Tel: 01903 737756
Email: planning@arun.gov.uk
www.arun.gov.uk/planning
Please ask for: Ms Iqraa Malik
Email: iqraa.malik@terraquest.co.uk
Telephone: 0121 234 1390
Our Ref: A/76/25/HH
Your Ref:
Date: 9th May 2025

Application for Planning Permission for Works or Extension to a Dwelling

Development: Erection of single storey rear extension.
Location: 10 Bramley Way Angmering BN16 4GA

Proposed block plan scale 1:500

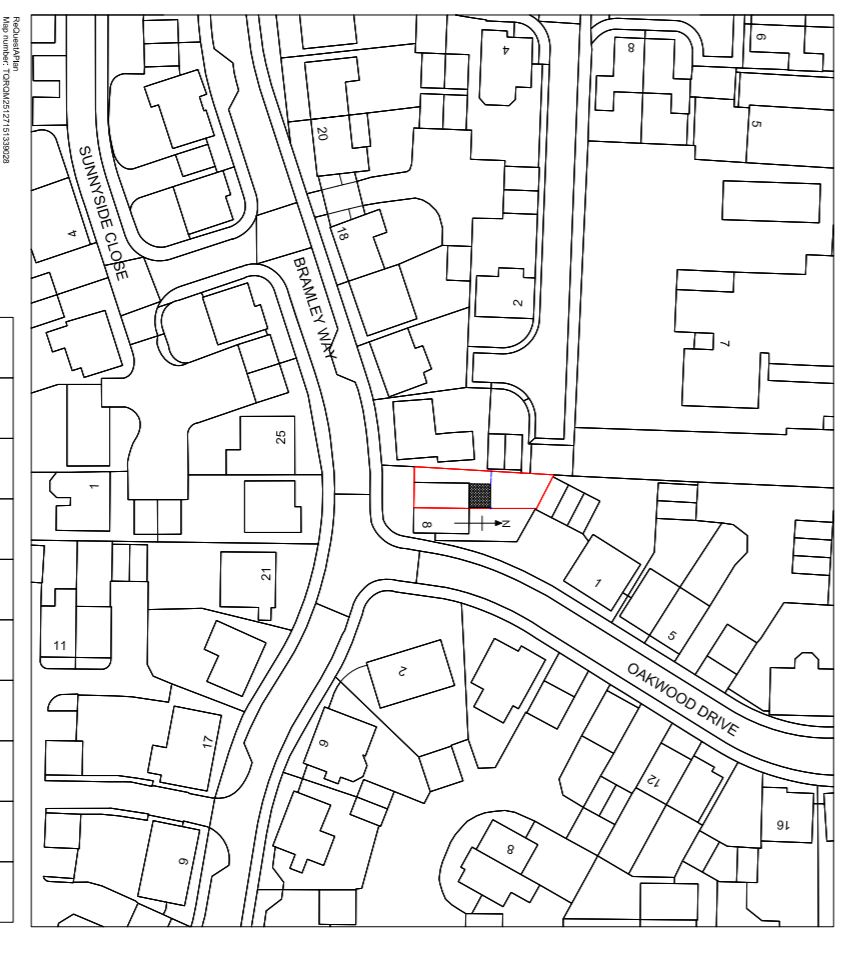
Block Plan

You are required to have dimensions from the proposed extension(s) to all site boundaries. Please amend.
